Application Ref:	3/2026/0405			 Ribble Valley Borough Council www.ribblevalley.gov.uk
Date Inspected:	26/06/26	Site Notice:	N/A	
Officer:	AR			
DELEGATED ITEM FILE REPORT:				APPROVAL

Development Description:	Proposed single-storey extension to rear of property.
Site Address/Location:	12 Shaw Brook Street Clitheroe BB7 1RX

Map 1 - Future surface water flooding

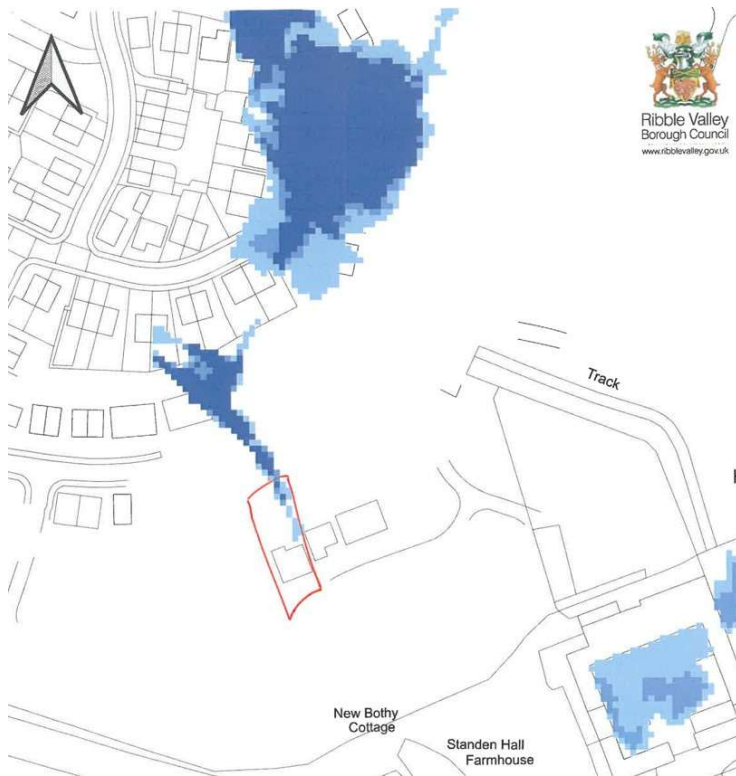
The flood map for the application indicates that part of the site is at risk of surface water flooding. The FRA addendum submitted refers to the comprehensive Flood Risk Assessment undertaken by AMEC Environment & Infrastructure, report ref. 12_0942_vol 3b, which was submitted as part of planning application 3/2012/0942 for the Half Penny Meadows Development. Given the small scale of the proposal and its location within an already developed and mitigated site, the proposed extension does not increase flood risk to the property or surrounding area. The conclusions and mitigation measures from the original AMEC (2012) Flood Risk Assessment remain valid and appropriate.

However, as a matter of caution given the risk identified within the garden of the property, the applicant will install water butts to remediate surface water discharging off the roof in times of heavy rainfall.

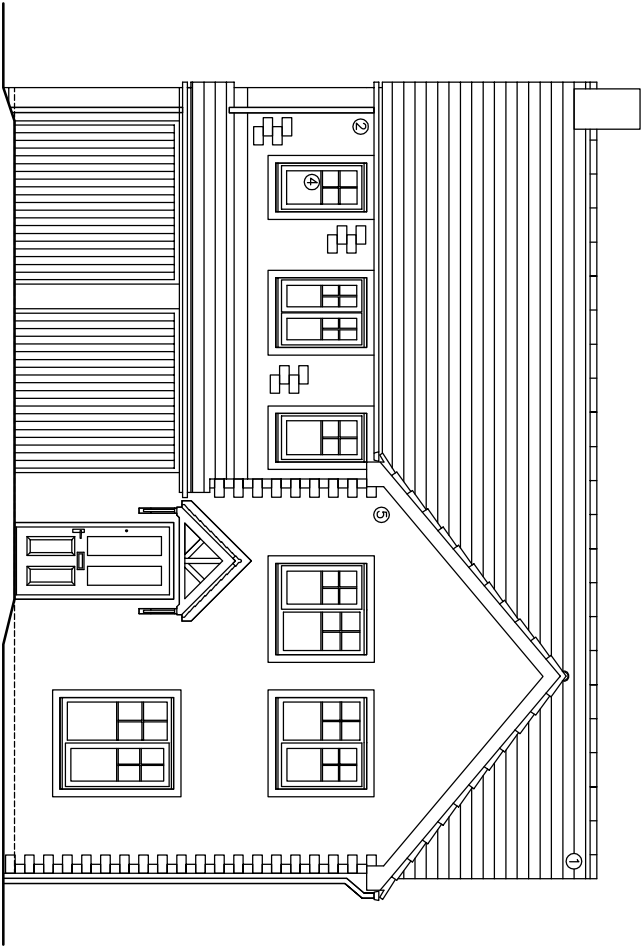
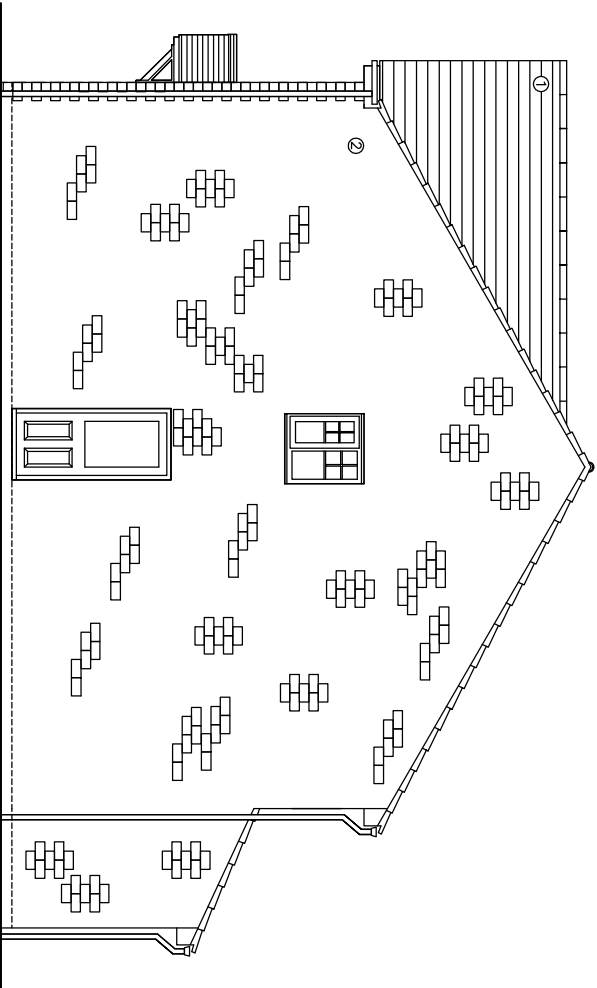
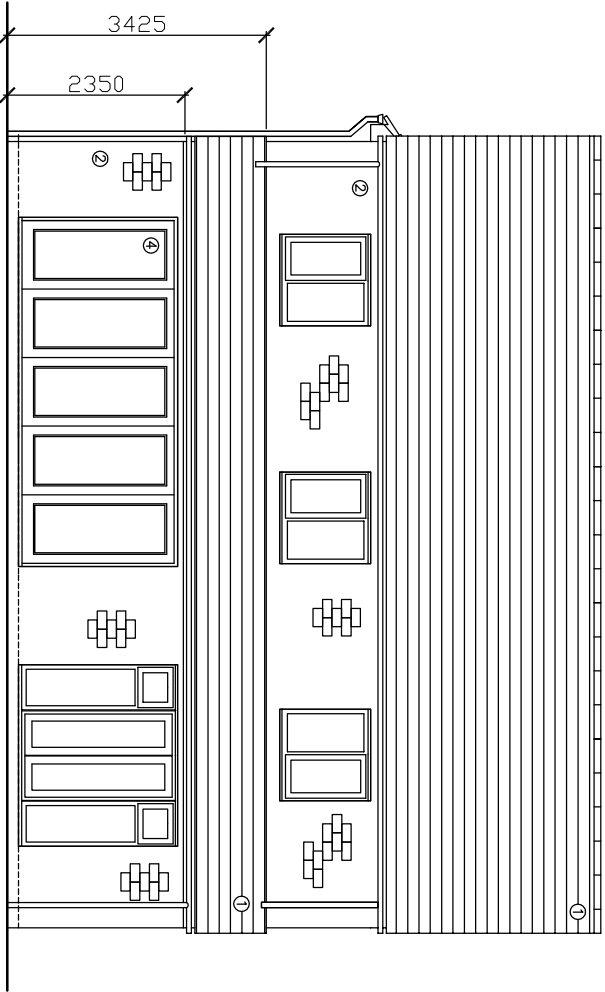
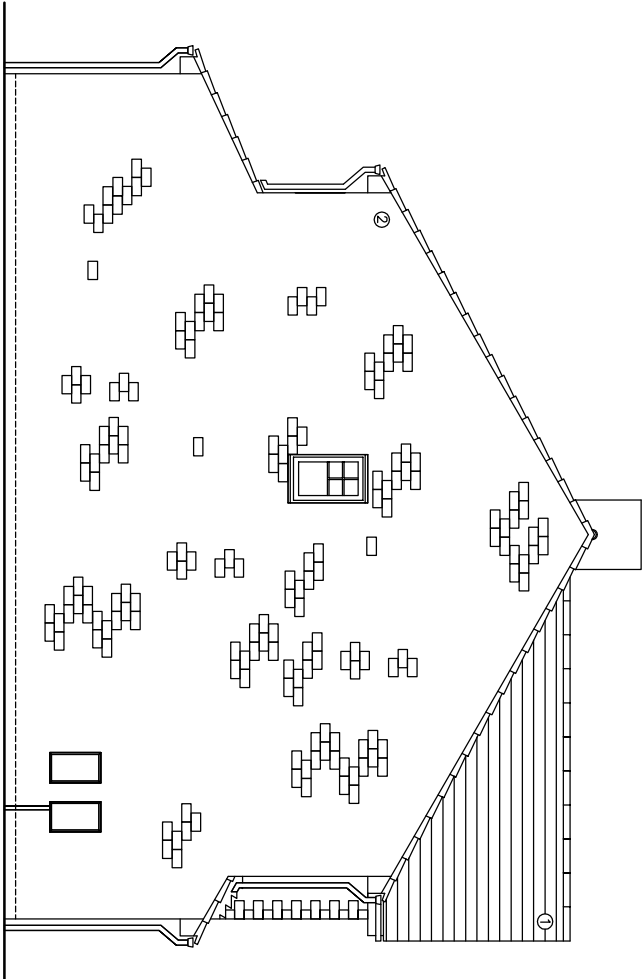
The openings proposed to the rear elevation would provide views predominantly towards the private amenity space associated with the application property, and therefore, no new opportunities for direct overlooking or loss of privacy are anticipated in this respect.

The proposed development is located to rear of the application dwelling and is of single storey nature. As a result, the development will not host a highly visible position within the street scene.

In terms of scale, the extension has a modest footprint, measuring approximately 1.57m in length and 5.84m in width. The eaves and ridge heights will match those of the existing rear at 2.35m and 3.42m, respectively. As such, the extension will match the architecture of the existing dwellinghouse and the neighbouring dwellings and will not read as an incongruous addition to the application site.

With regard to materiality, the extension would feature natural coursed stonework, concrete roof tiles and UPVC/Aluminium windows and doors to match the existing dwellinghouse.
